**Re: ABB ABQ Expansion – 6625 Bluewater Rd NW
Erosion and Sediment Control Plan
Engineer's Stamp Date – 12/7/2023 (K10E011)**

Based upon the information provided in your submittal received 12/8/2023, the above referenced ESC Plan can't be approved until the following comments have been addressed.

ABB ABQ ADDITION  
6625 BLUEWATER ROAD NW  
MAJOR AMENDMENT  
OVERALL LANDSCAPE PLAN

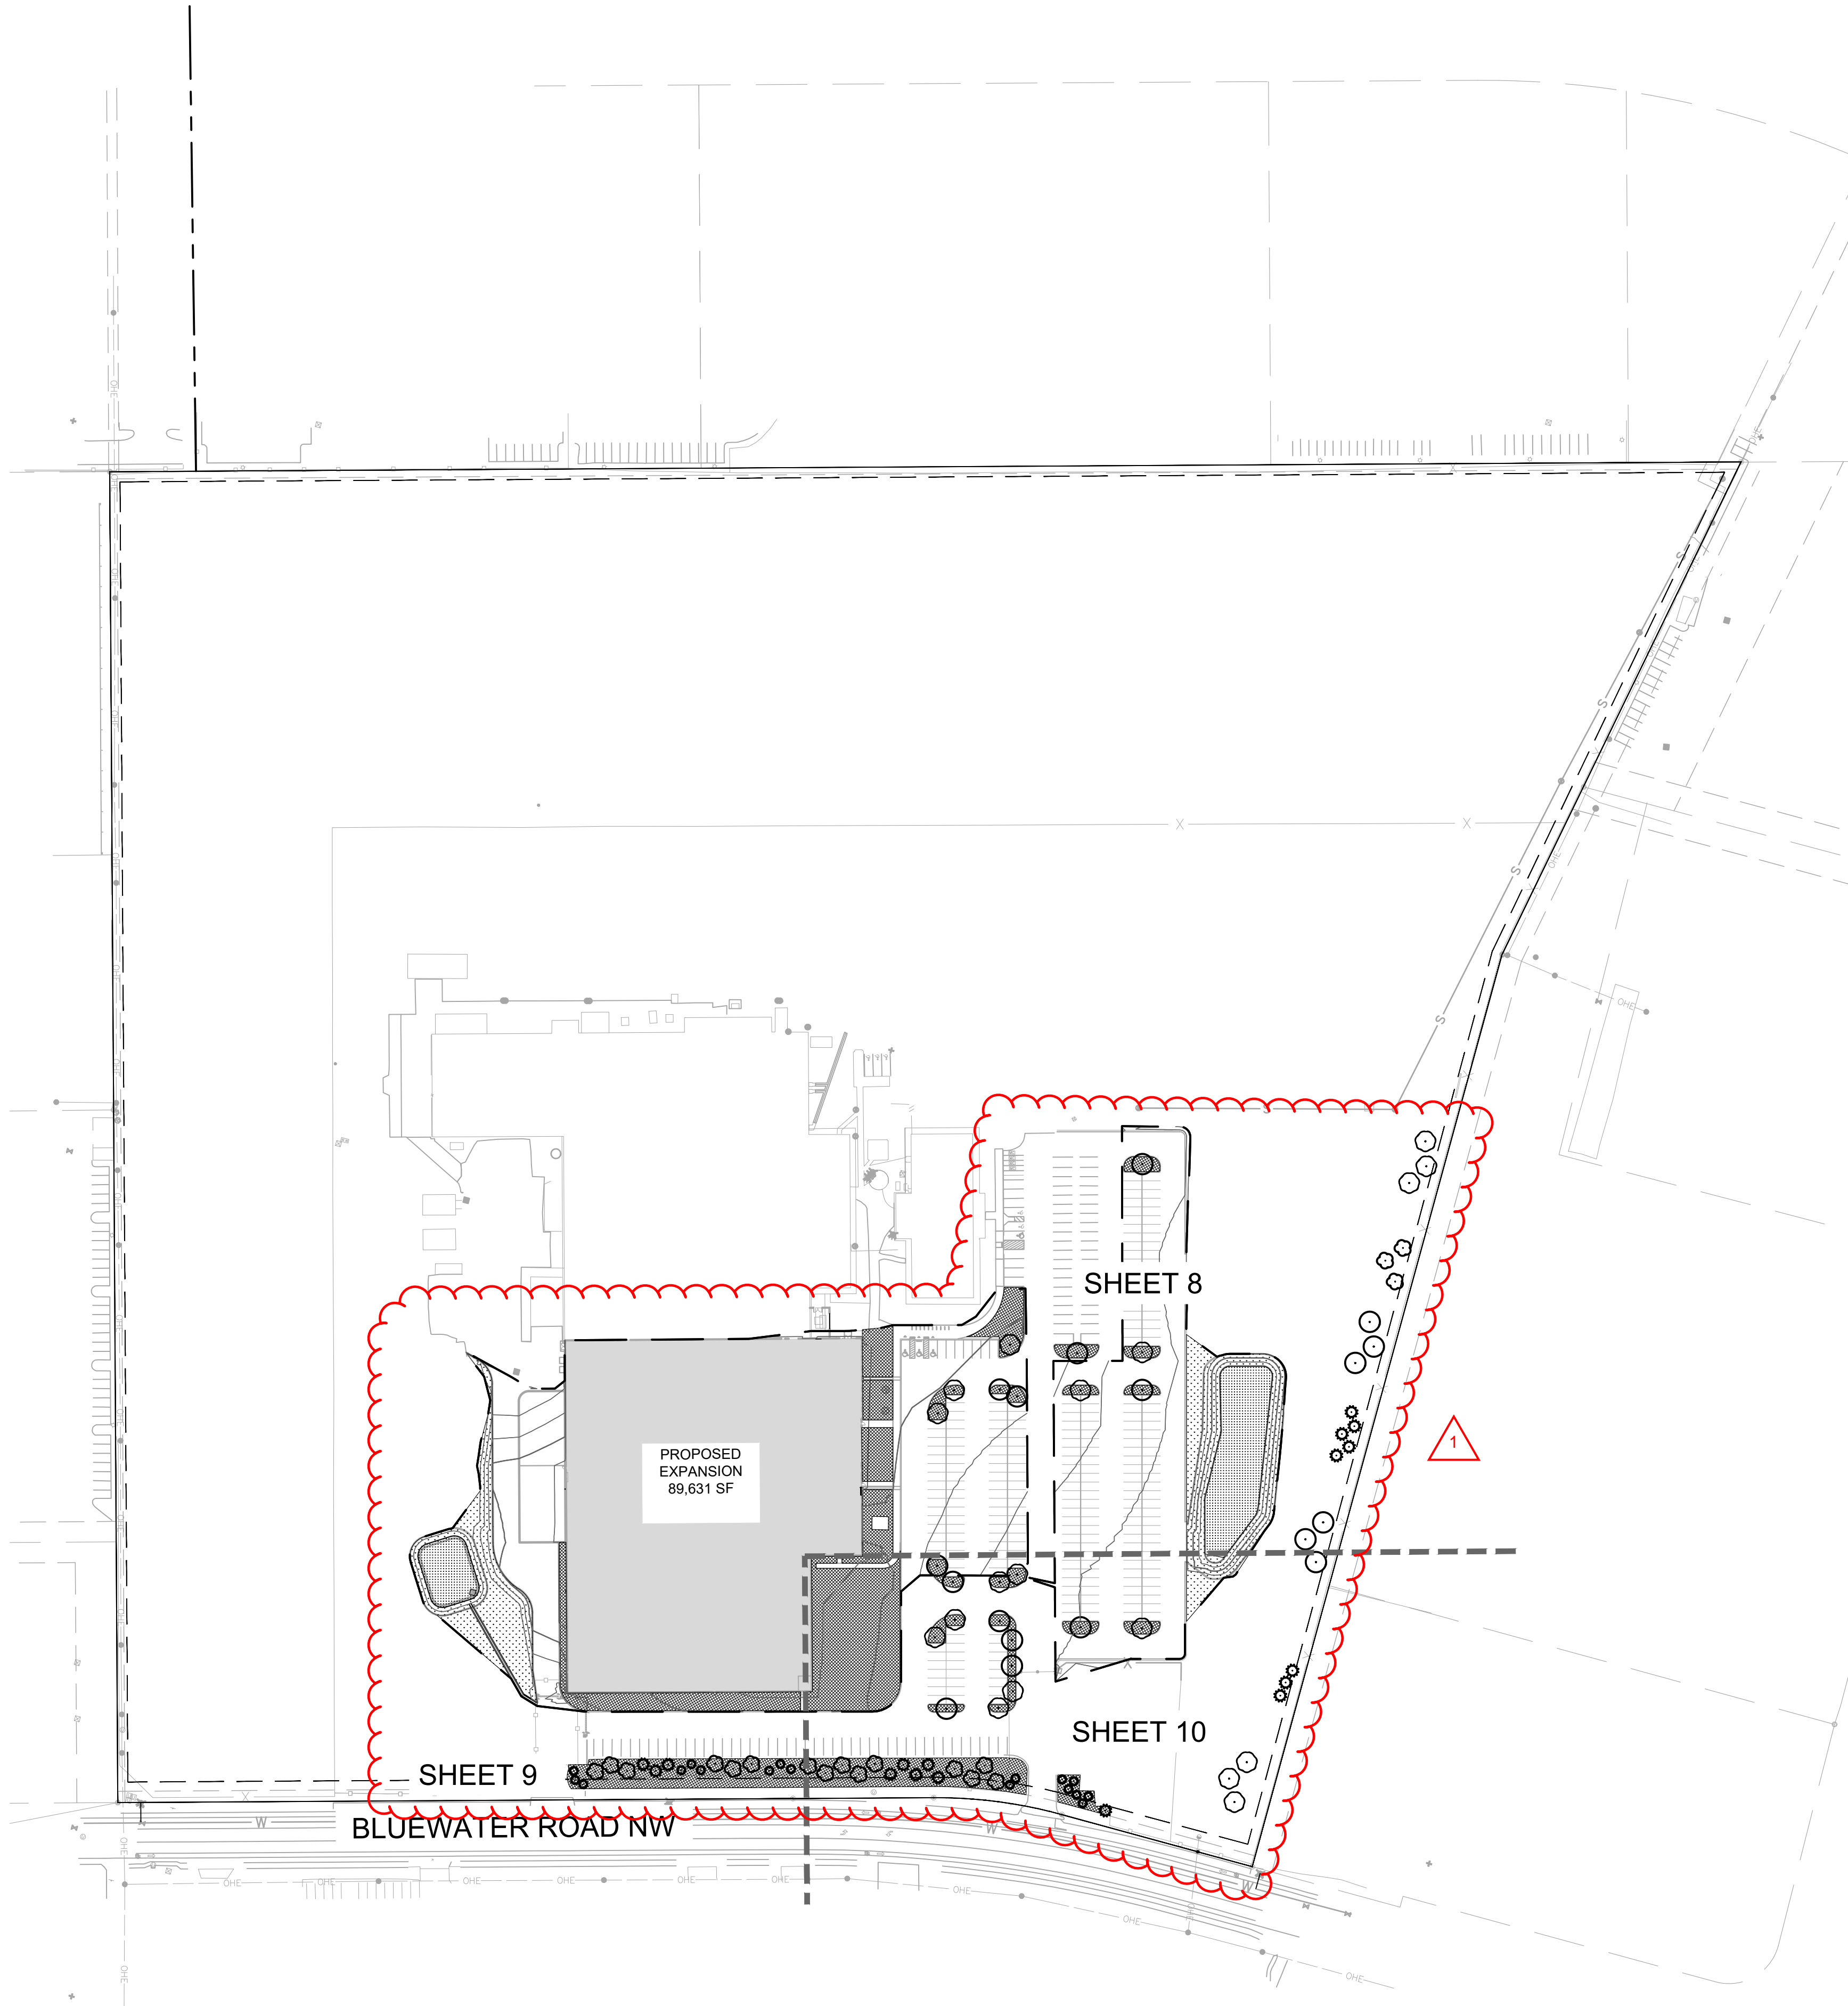
4. The SWPPP must include site-specific interim and permanent stabilization specifications per CGP 9.4.1.c.i. The Landscape Plan and/or Site Plan can be used to satisfy this requirement and should be submitted separate from the ESC Plan with the application to

the Stormwater Quality Section of the Planning Department and it should be included in the SWPPP. Provide a specification on the ESC Plan for any disturbed areas not covered by the Landscape Plan or Site Plan sheets.
